MEMORANDUM

DATE: December 6, 2023  
TO: Ryan Howser, PCD-Project Manager  
FROM: Jeff Rice, PCD-Engineering  
719-520-7877  
SUBJECT: SF-22-025 – Eagle Rising  
Third Submittal

**May 21, 2024**  
**Response to Engineering Comments**

EAGLE RISING FILING NO. 1
 A PORTION OF THE EAST HALF (E 1/2) OF SECTION 29, TOWNSHIP 12 SOUTH,
 RANGE 65 WEST OF THE SIXTH PRINCIPAL MERIDIAN, EL PASO COUNTY, COLORADO

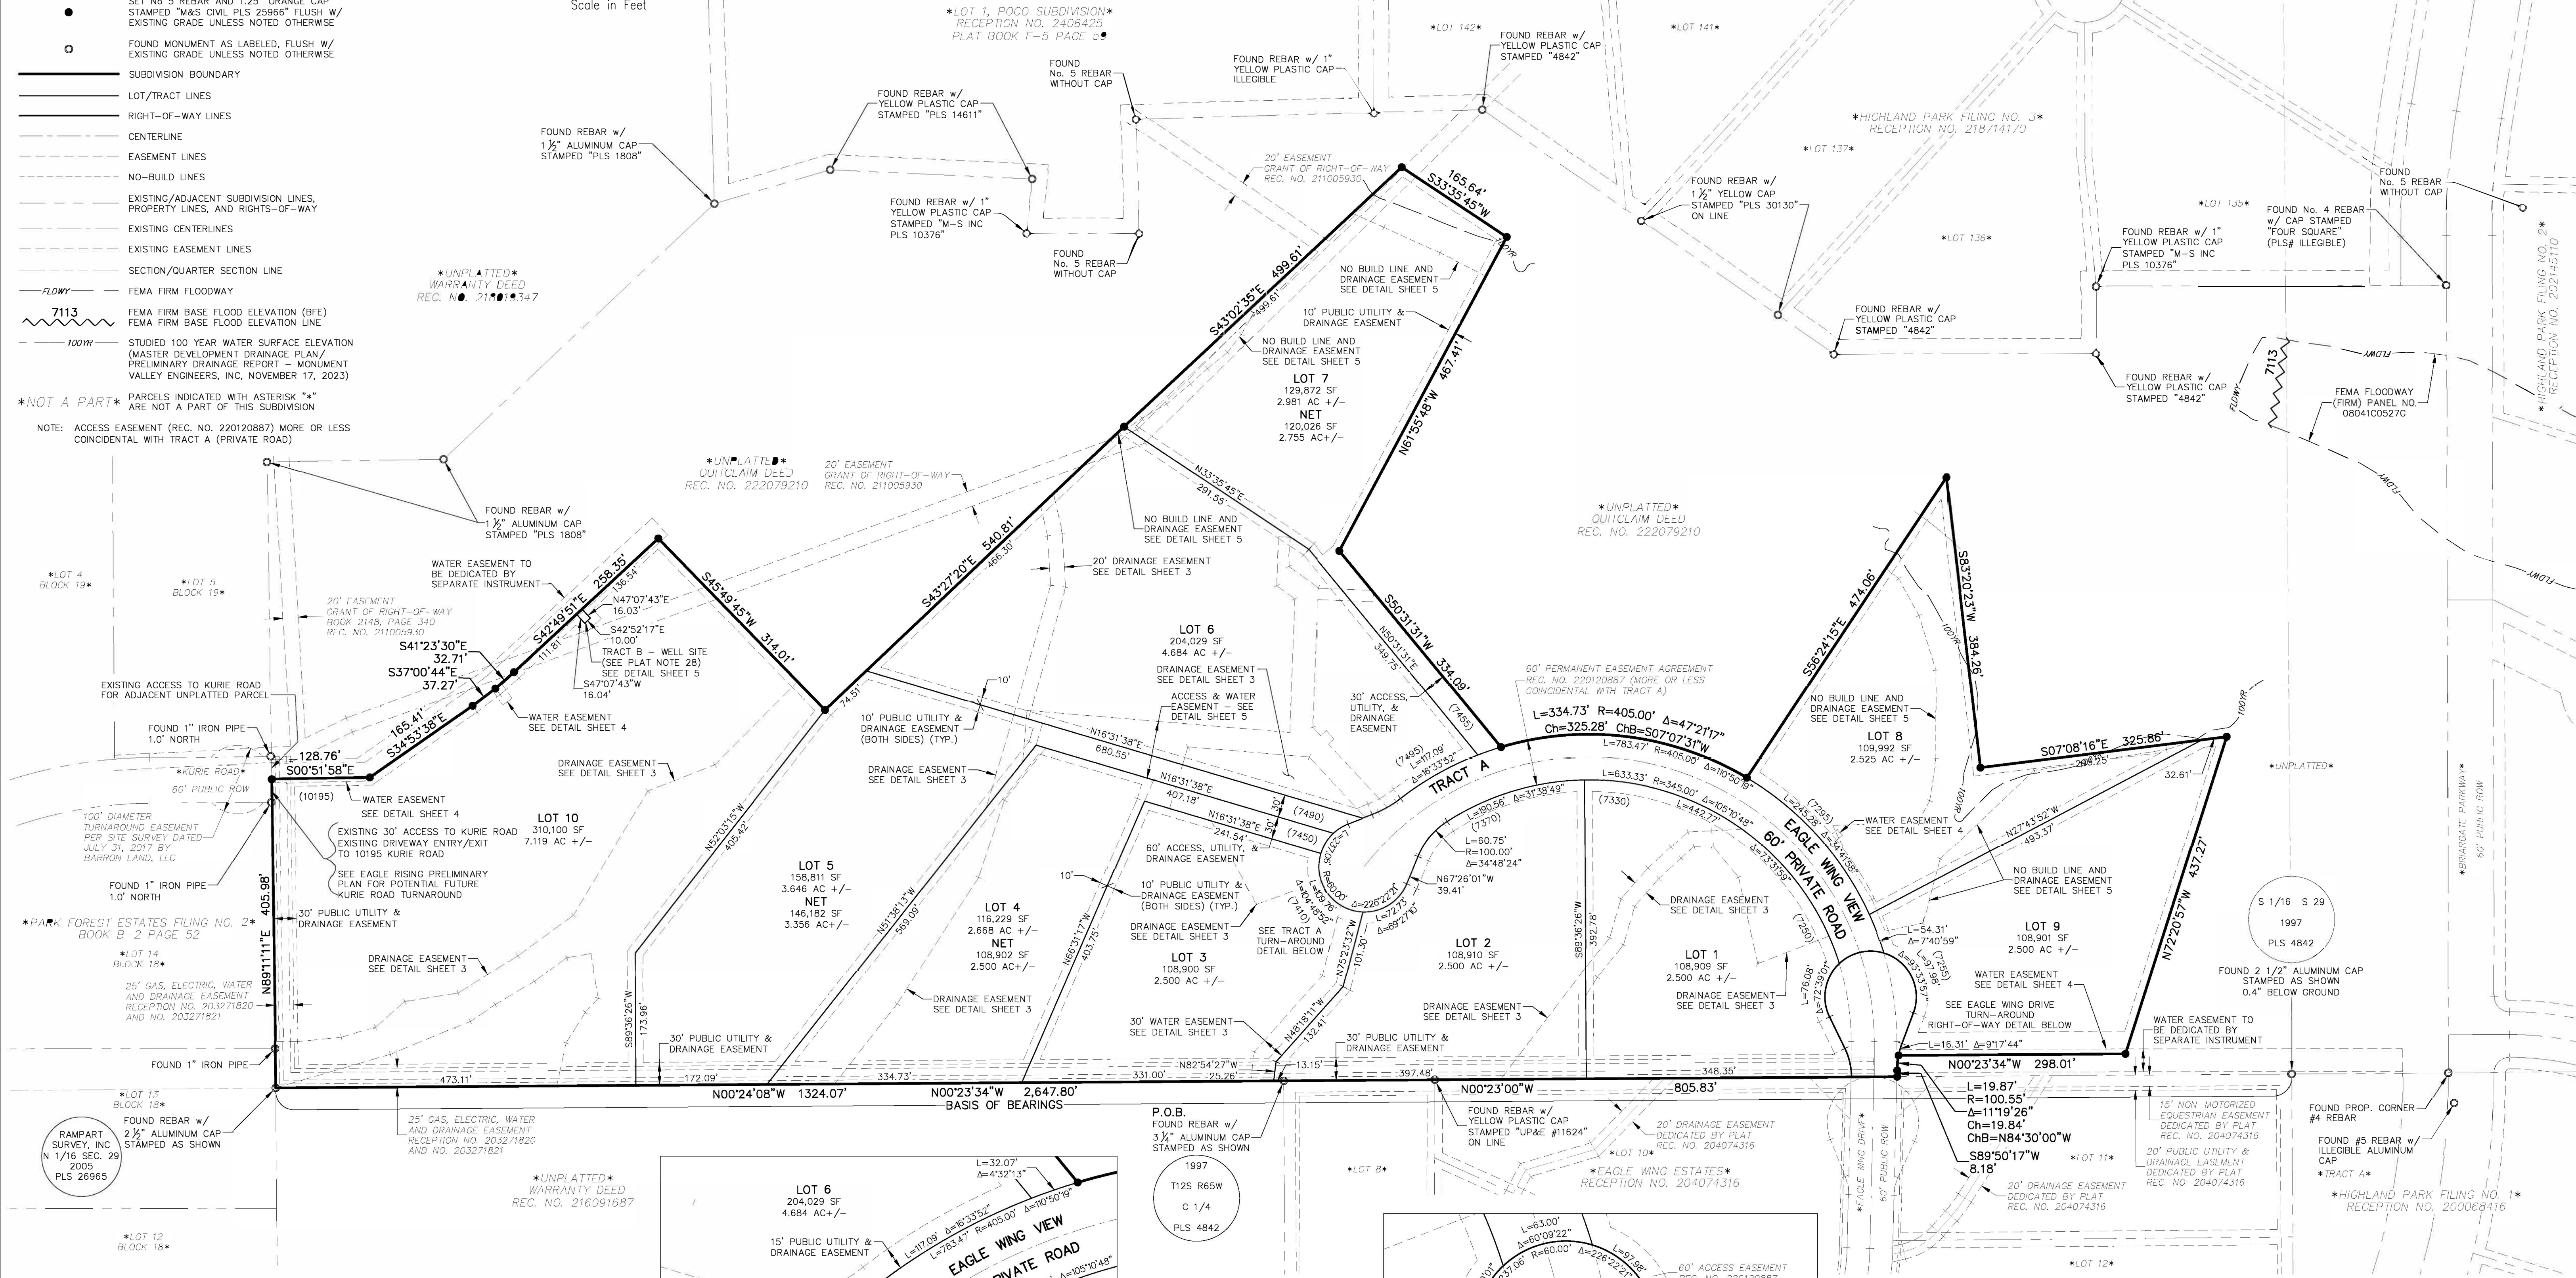
**Unresolved; see modified version of the note on plat redlines. Response: See Final Plat Note 26**
4. The plat must dedicate right of way for a cul-de-sac at the south end of Kurie Road. Cul-de-sac dimensions need to match dimensions shown in the standard drawing for cul-de-sac details in the Engineering Criteria Manual so that County vehicles attempting to maintain the roadway and

emergency service vehicles may turn around in the public cul-de-sac. Revise Lot 8 as appropriate. **Unresolved; the portion of the necessary ROW within the final plat area shall be provided in conformance with the preliminary plan.** Response: The Preliminary Plan shows the complete development of two parcels, 5229000034 and 5229000035. Eagle Rising Filing No. 1 is the final plat for only the western parcel (5229000034). The final plat for Filing No. 1 contains the necessary elements to serve the single-family residential lots as depicted on the Filing No. 1 plat.

**The approved Preliminary Plan indicates a turnaround will be required for more than two parcels/lots to access Kurrie Rd.**

An additional Kurrie Road Cul-de-Sac Right of Way is not required on Final Plat Eagle Rising Filing No. 1. Minimum frontage access meets LC 8.4.3.B.e as shown on the plat. See Access Easement Detail Sheet 3 showing the existing approved driveway 30' access easement to Kurrie Road that is platted as a permanent existing turnaround. No additional ROW needed.

DRAINAGE EASEMENT DETAILS
 LOTS 3 & 6
 SCALE: 1" = 50'

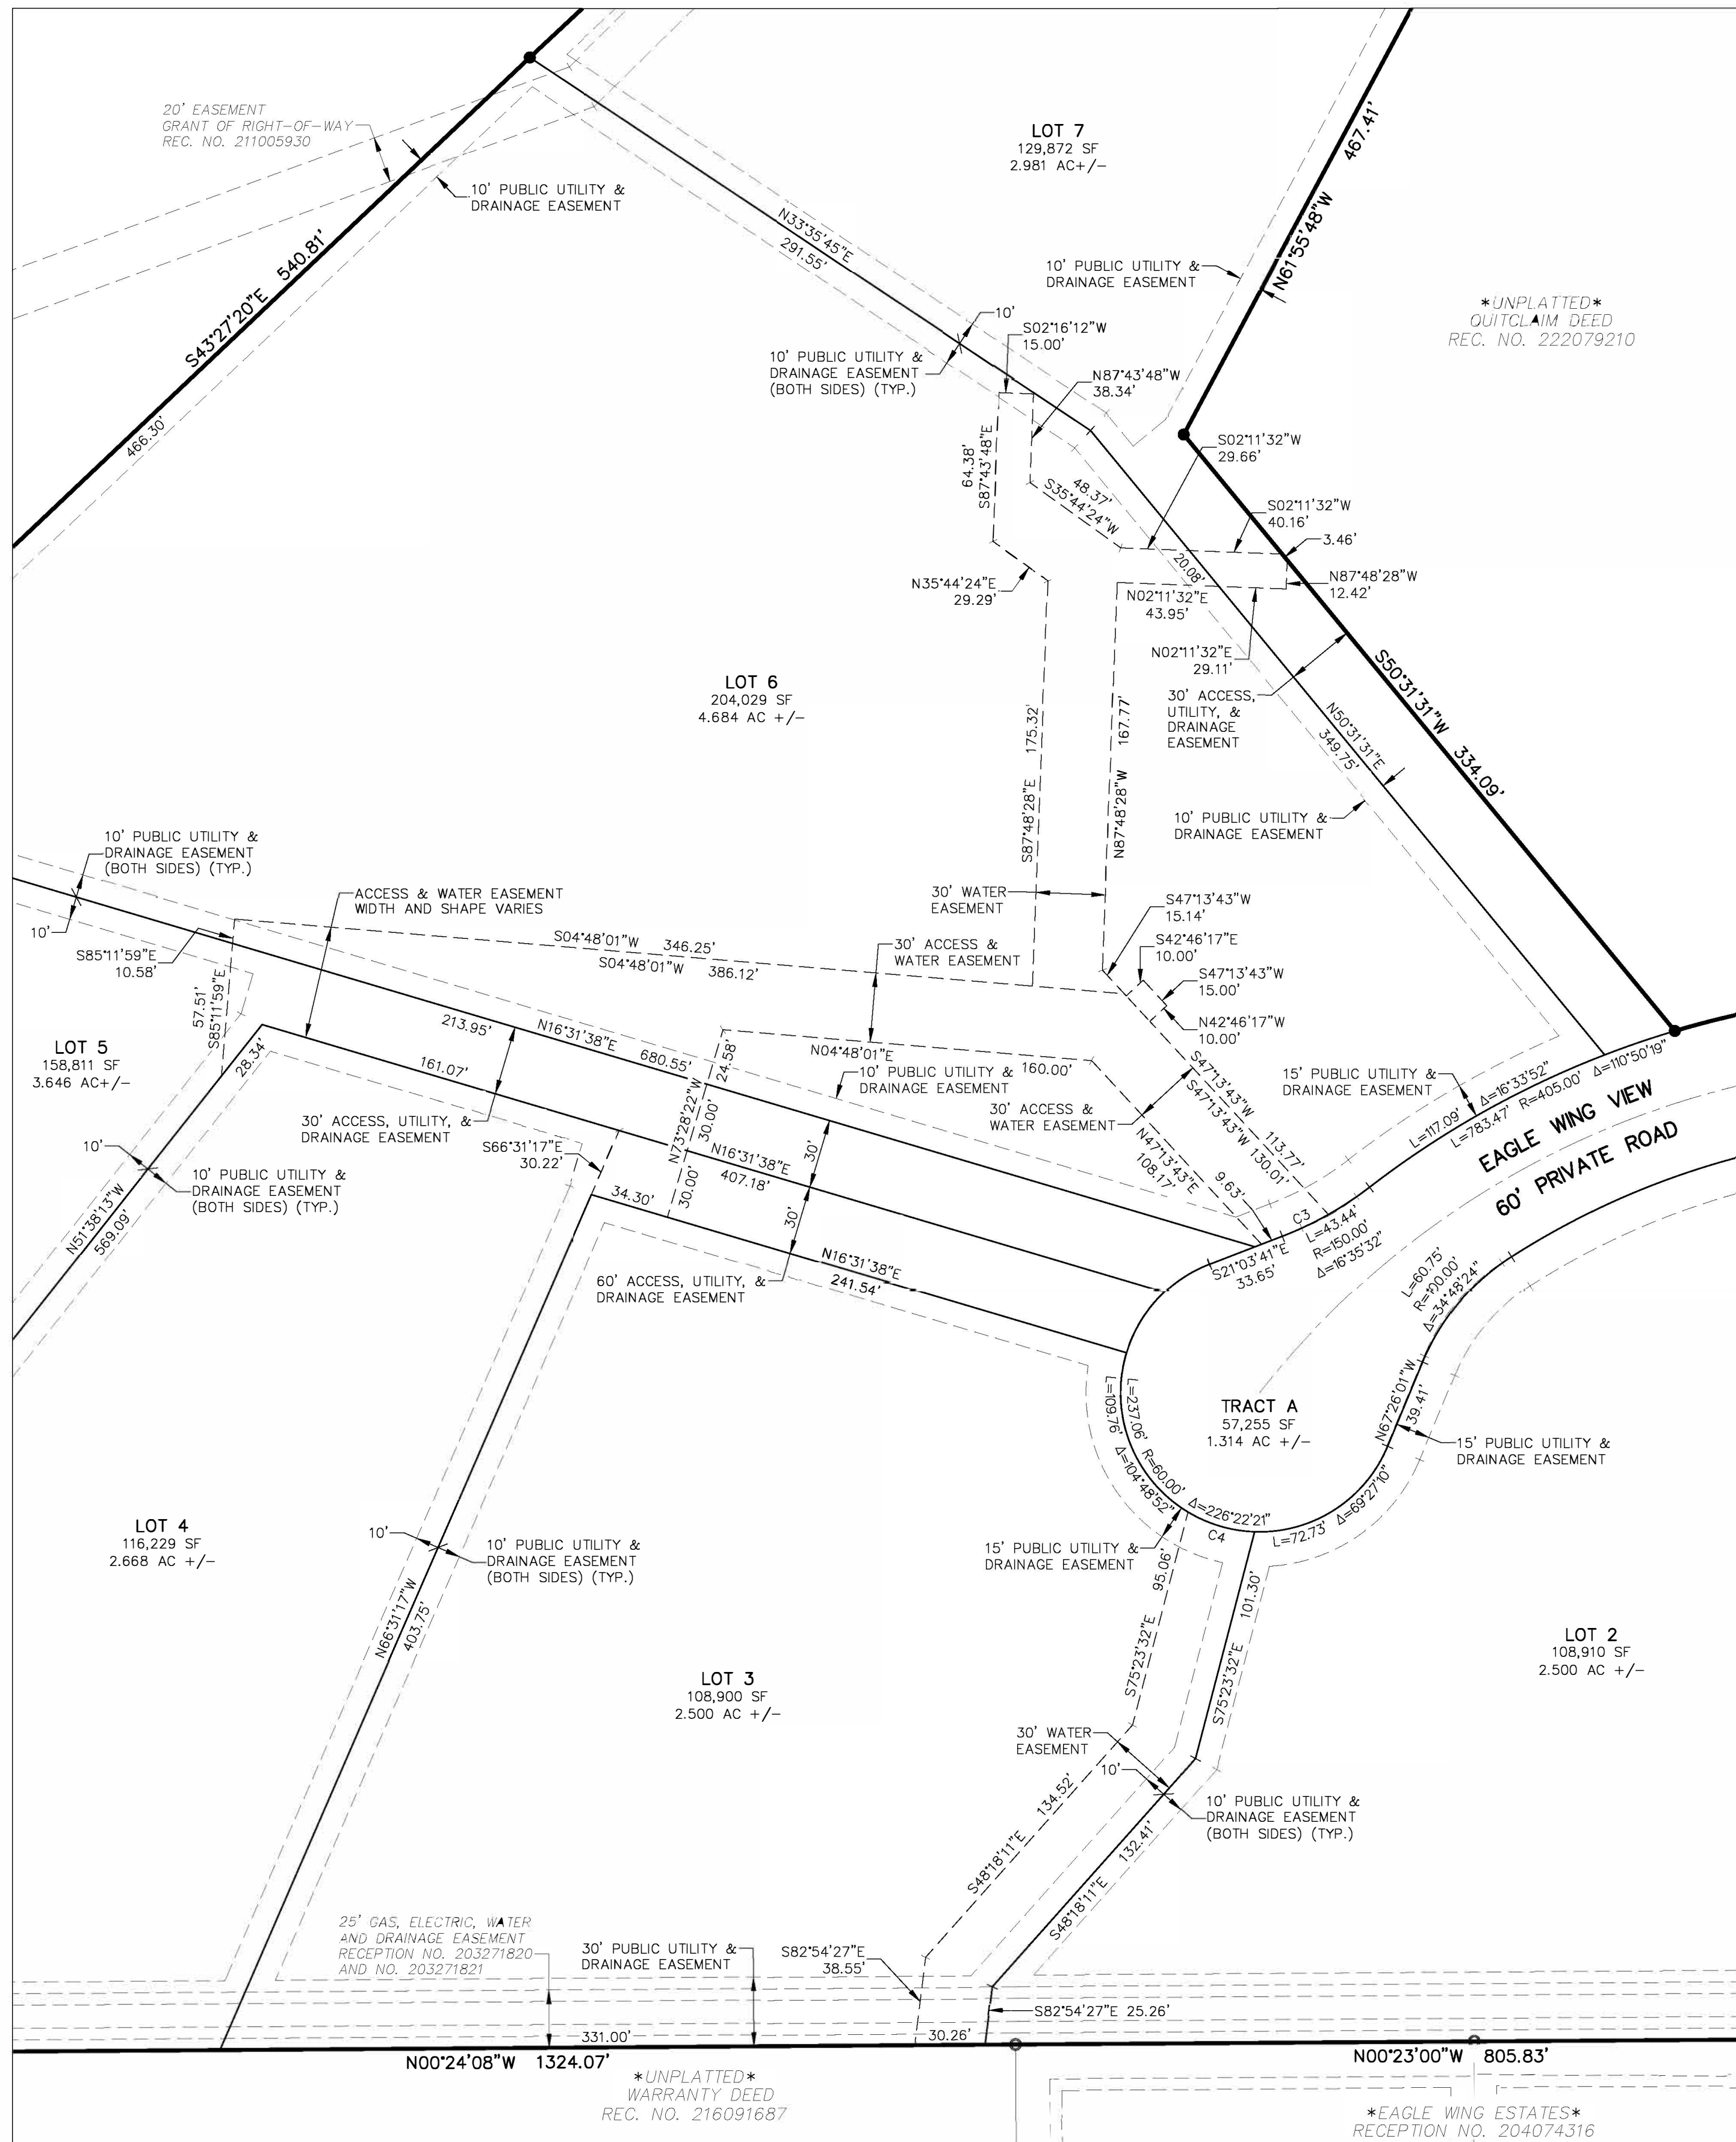
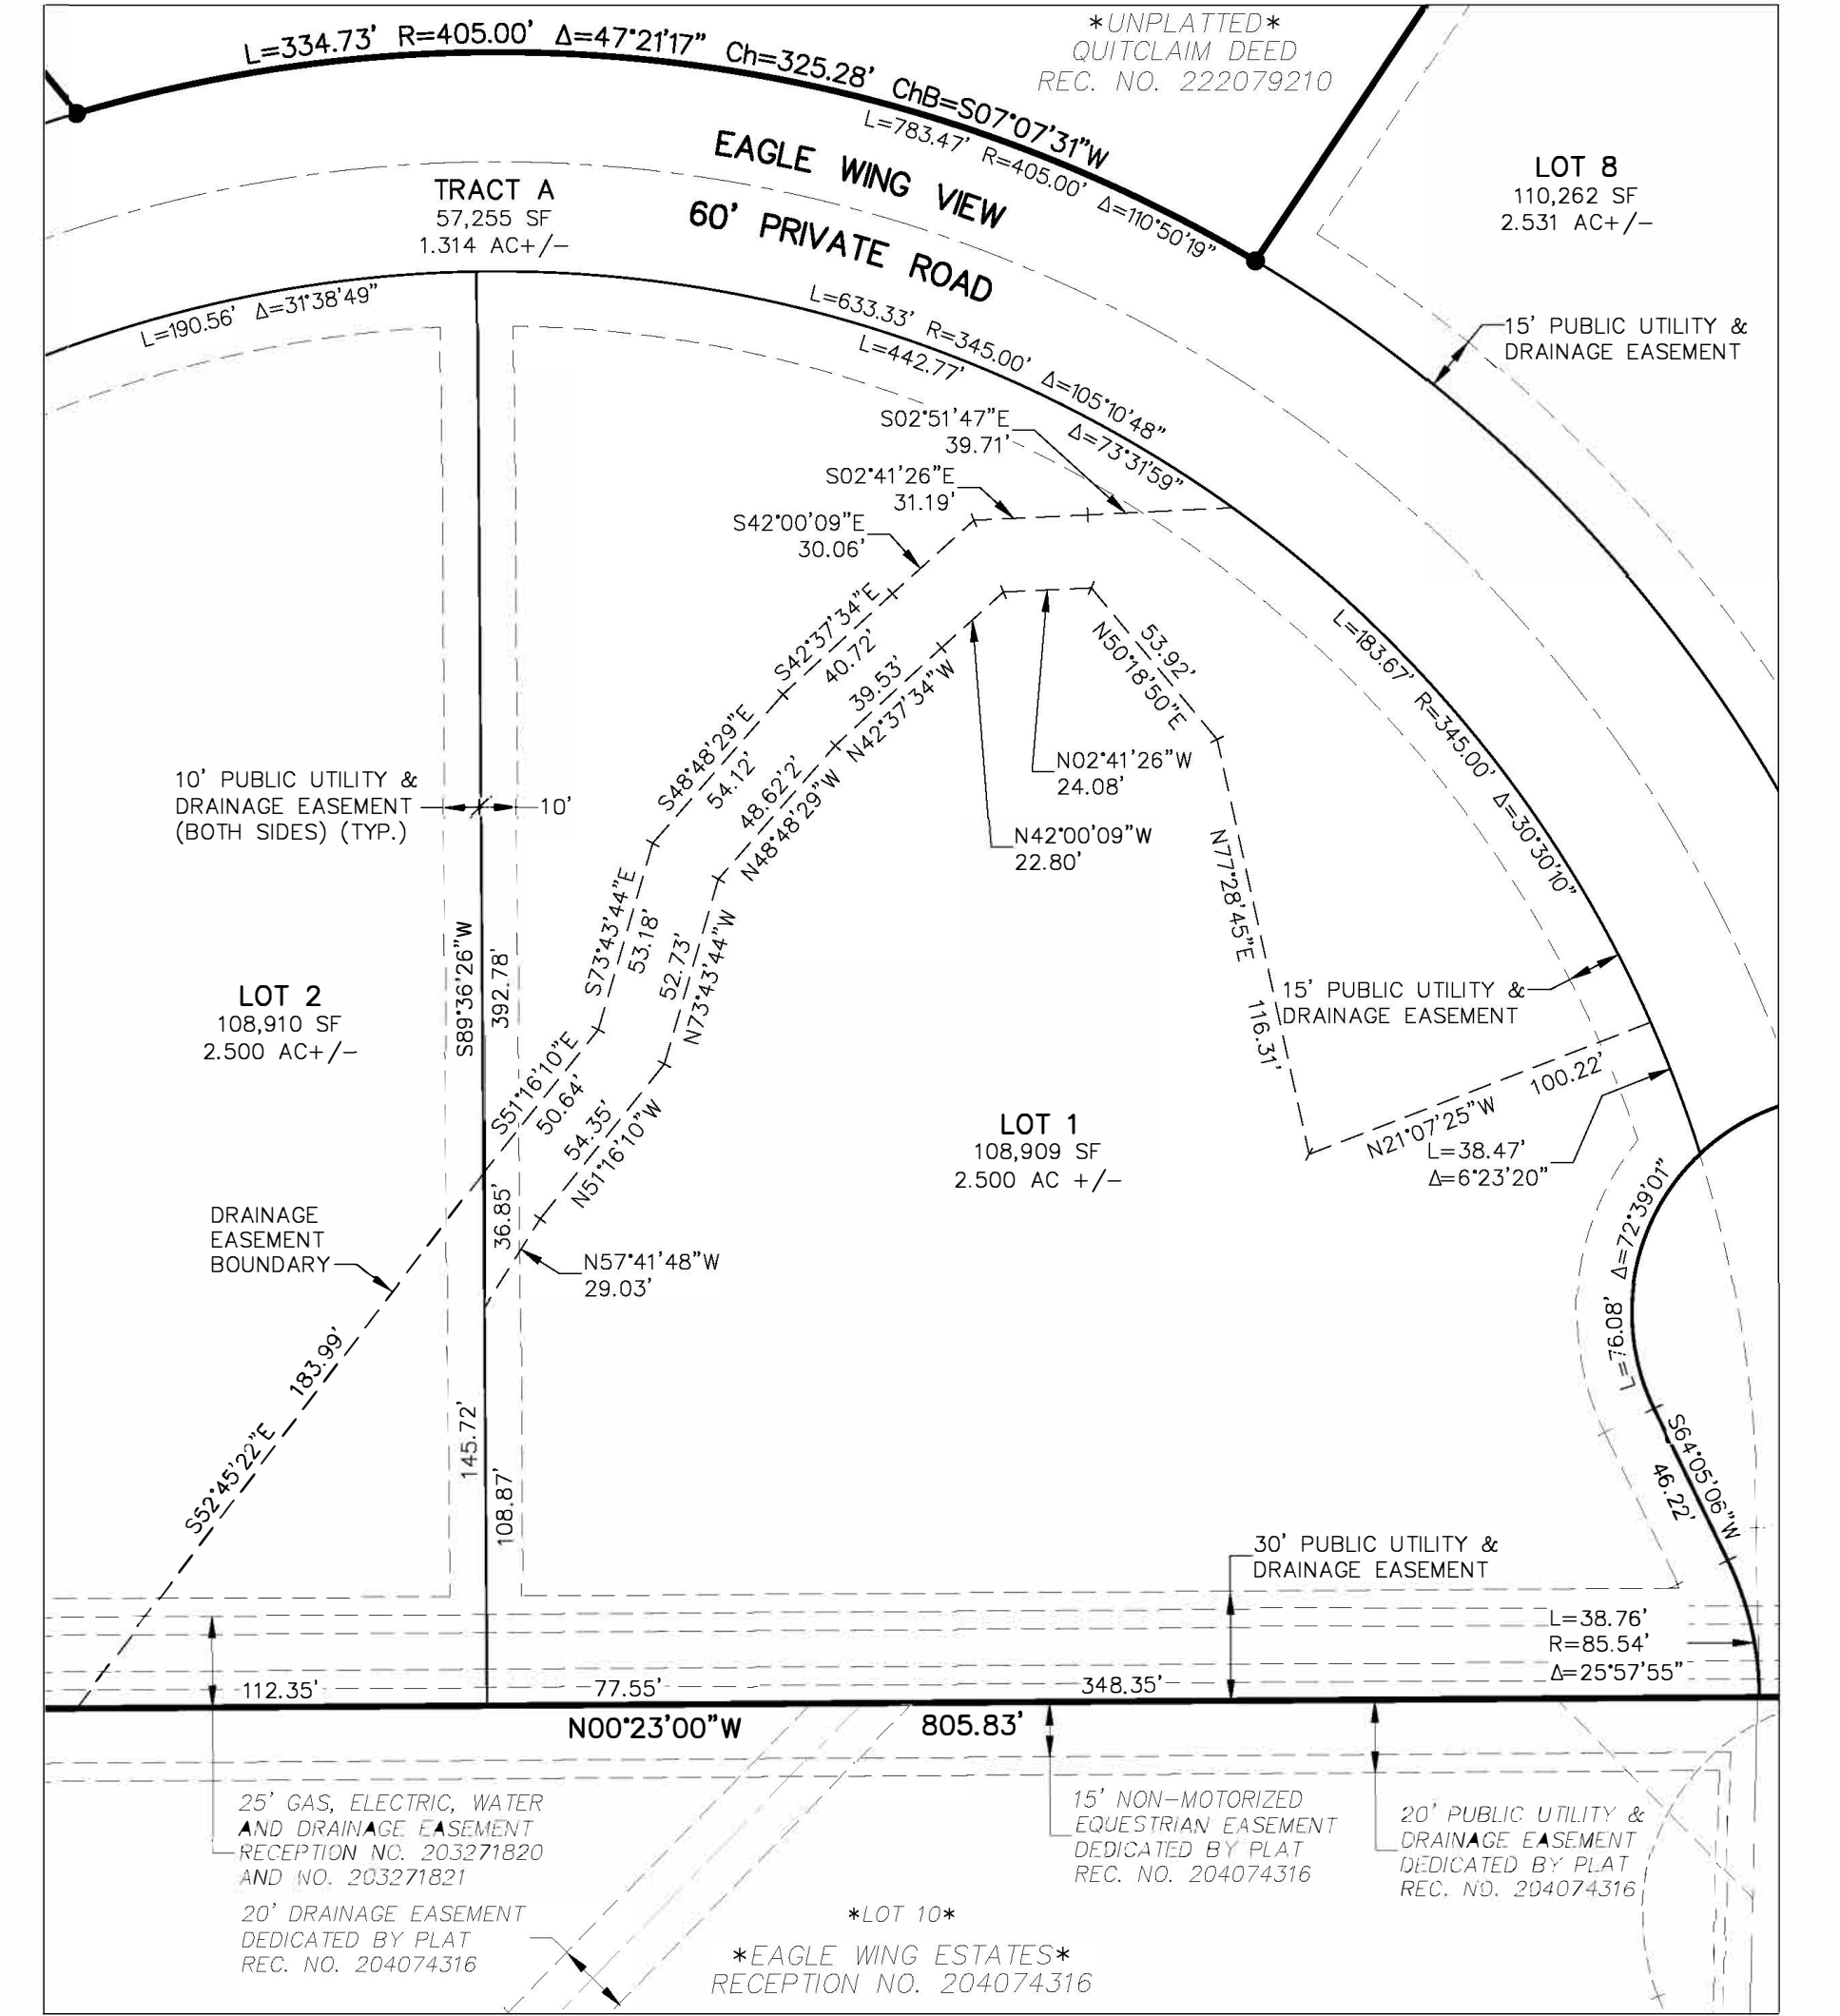
6. Discuss maintenance access provisions (for channels and BMPs), maintenance requirements and responsibility, and the Private BMP Maintenance Agreement and Easement that will be provided for the channel and any required PBMPs. Per criteria, a 15 foot wide access easement and an all-weather access road is required on each side of the main channel.

**Partially resolved; see redlines. Response: Resolved with the approval of the Creek Drainage Deviation of 4/16/2024 and the MDDP/PDR. Access is provided along the lot line Drainage Easements as indicated in the Deviation, Final Drainage Report, and Final Plat Filing #1.**
